Your Ref: MP 09_0187 MOD 3

MODIFICATION REQUEST – SECTION 75W MODIFICATION TO MIXED USE DEVELOPMENT AT 6-16 ATCHISON ST, ST LEONARDS (MO-09_0187 MOD 3)

I refer to your letter dated 2 June 2014 concerning the above matter. The proposed modifications have been reviewed by Council Planners and are not supported the reasons set out below.

e. info@holdmark.com.au www.holdmark.com.au

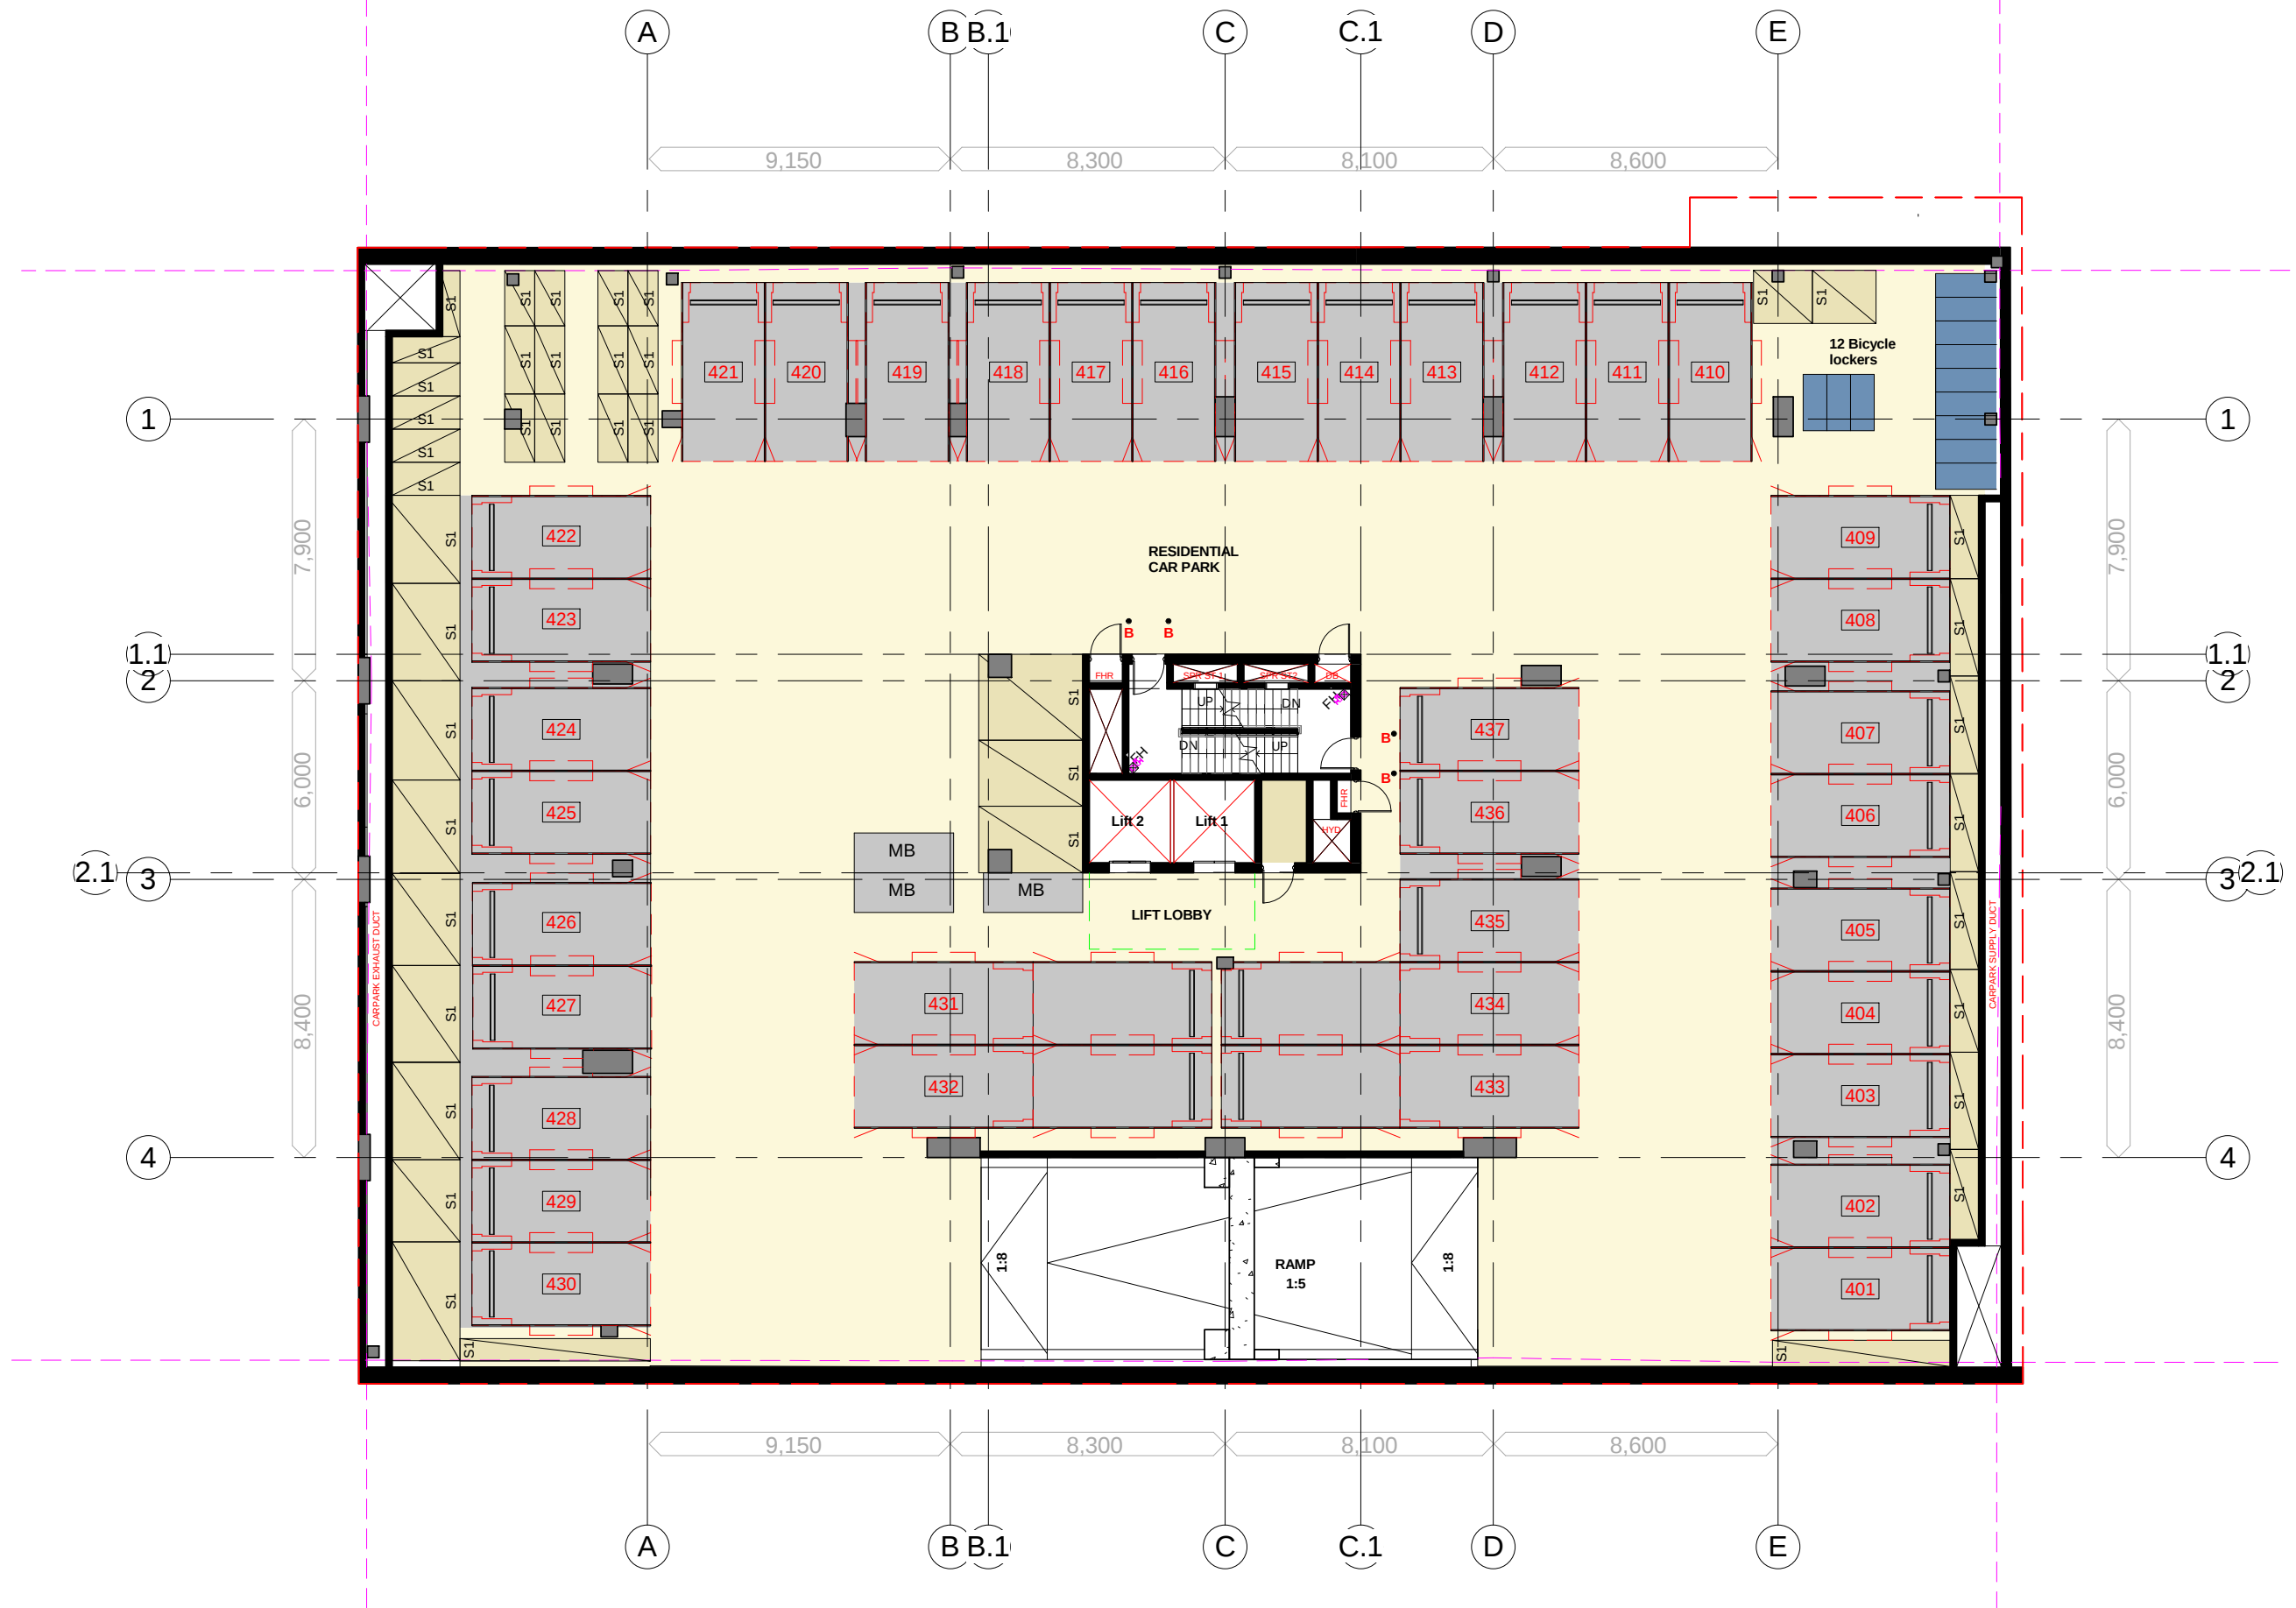
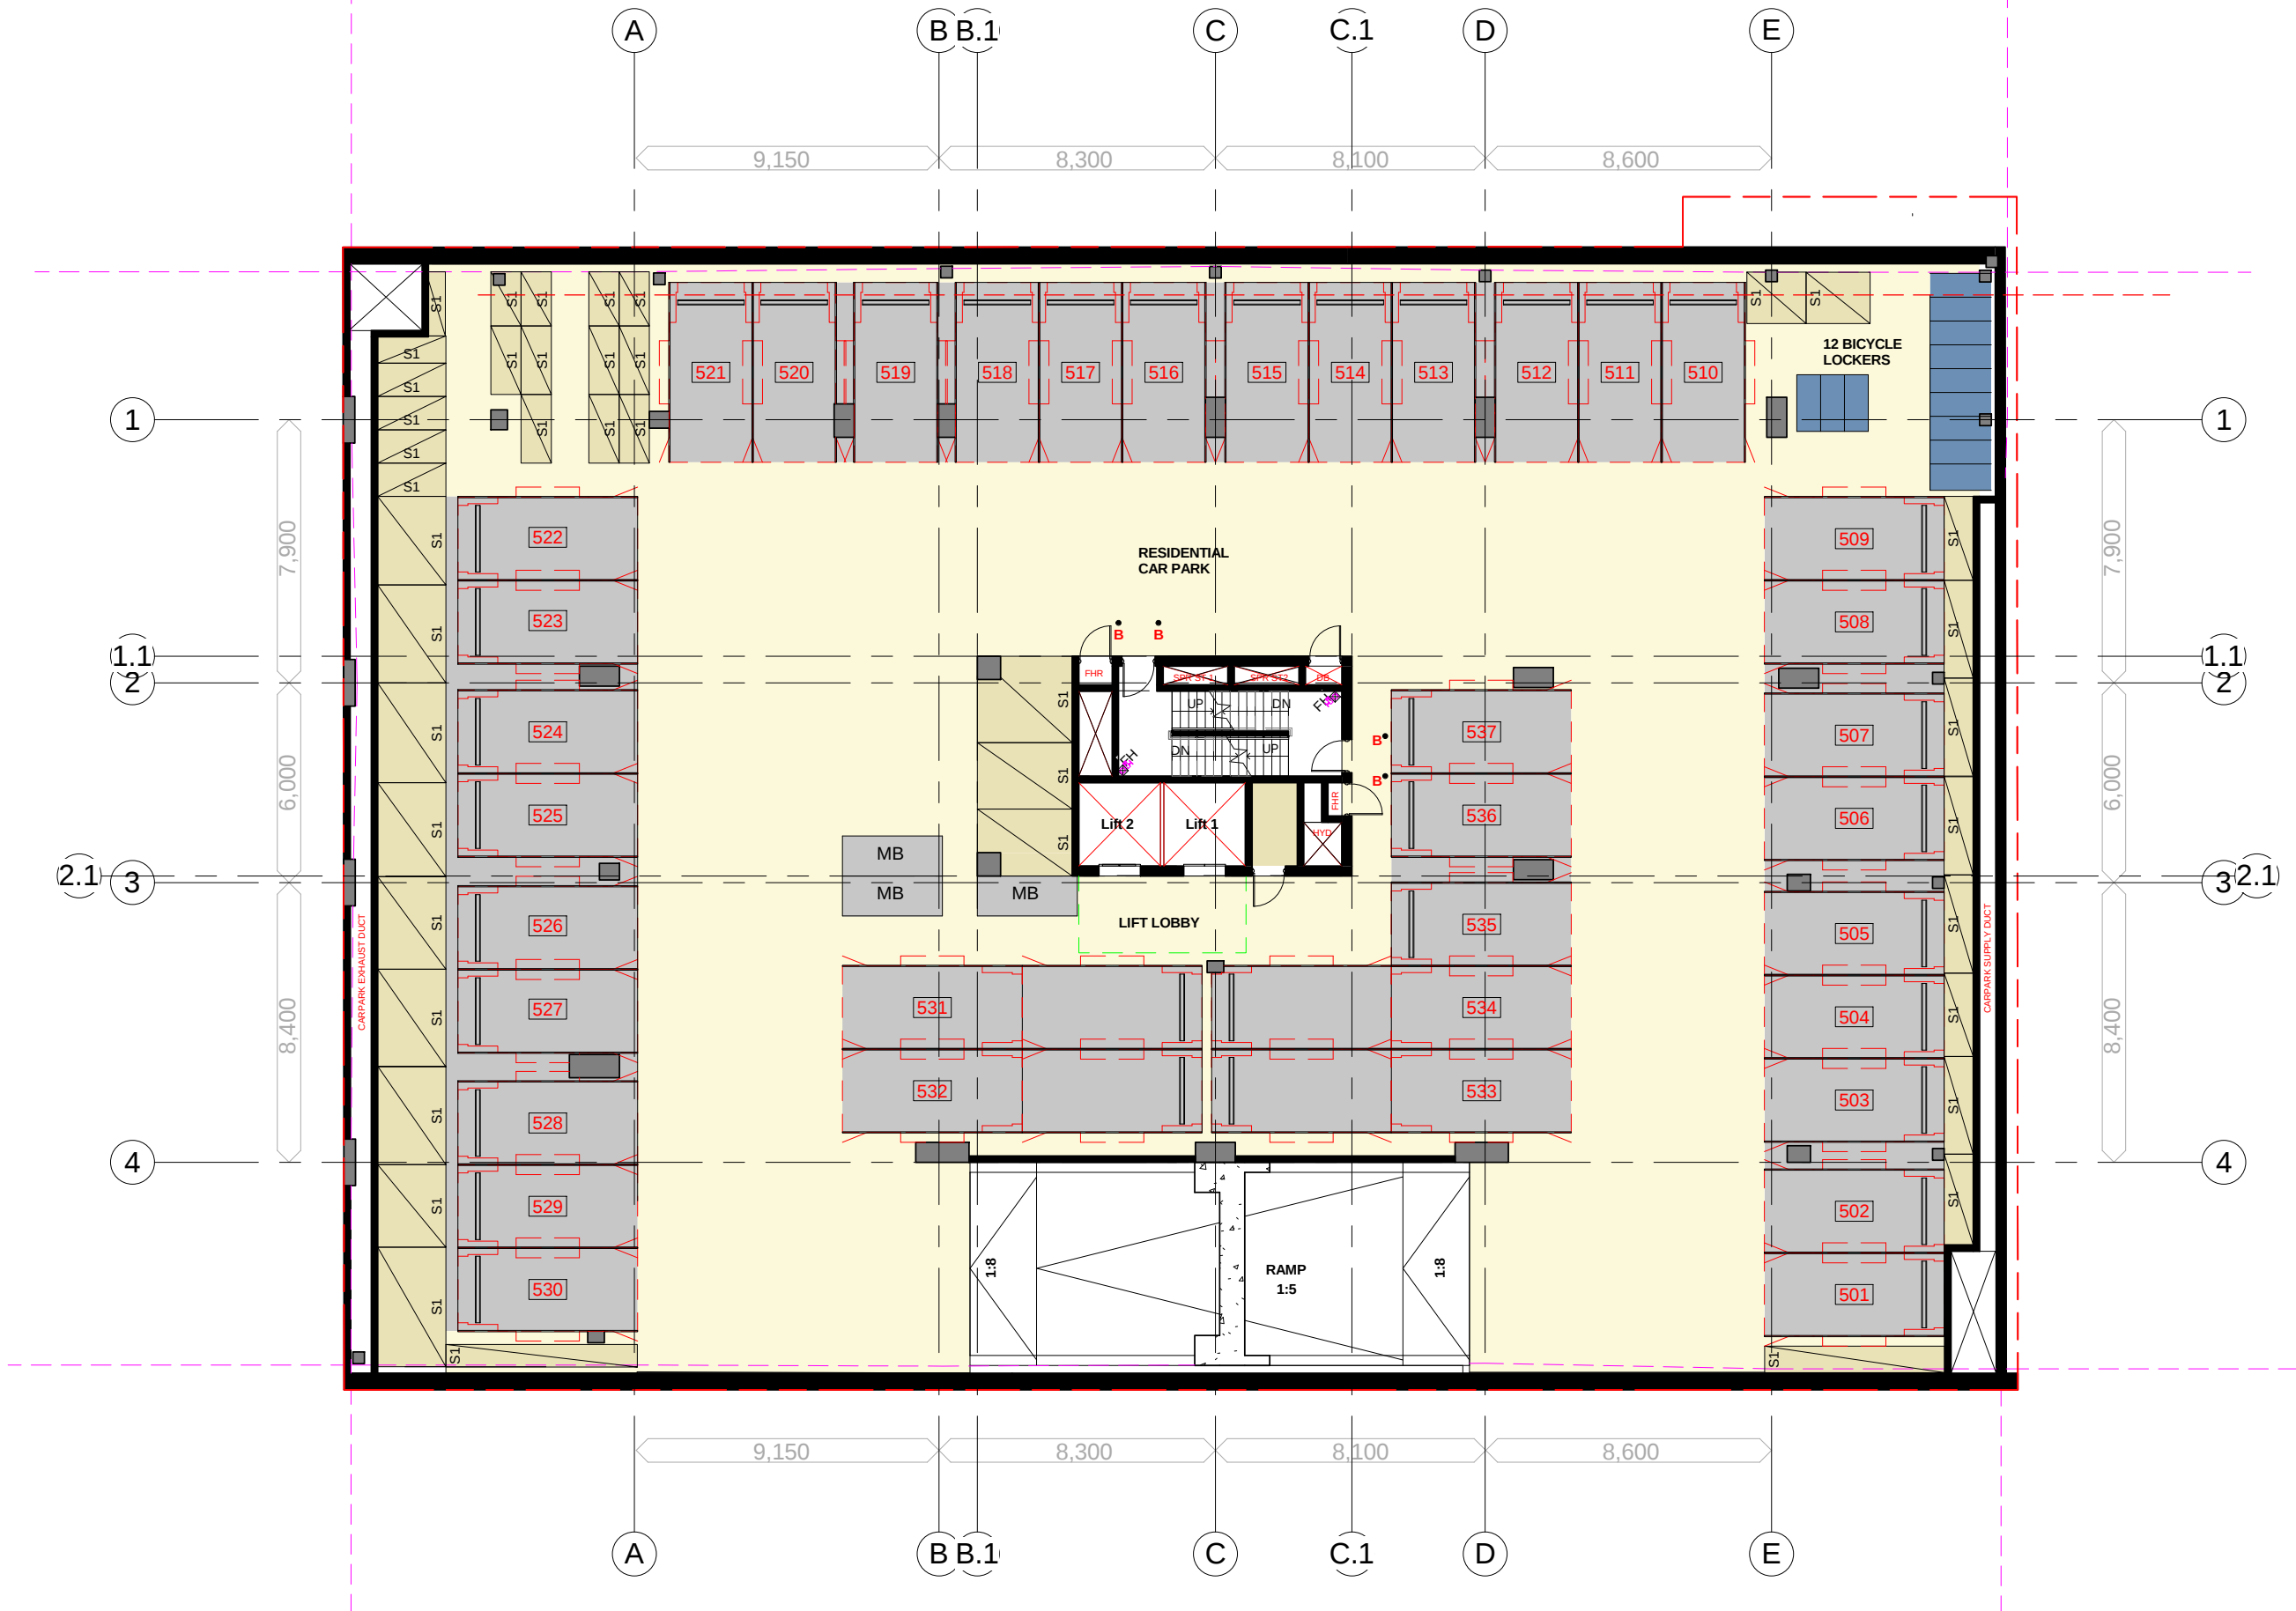
In addition, the modification proposes to provide an additional 34 car parking spaces within the approved 6 basement levels. Concern is raised that the basement has been already approved to accommodate this quantum of additional car parking that has not yet been approved.
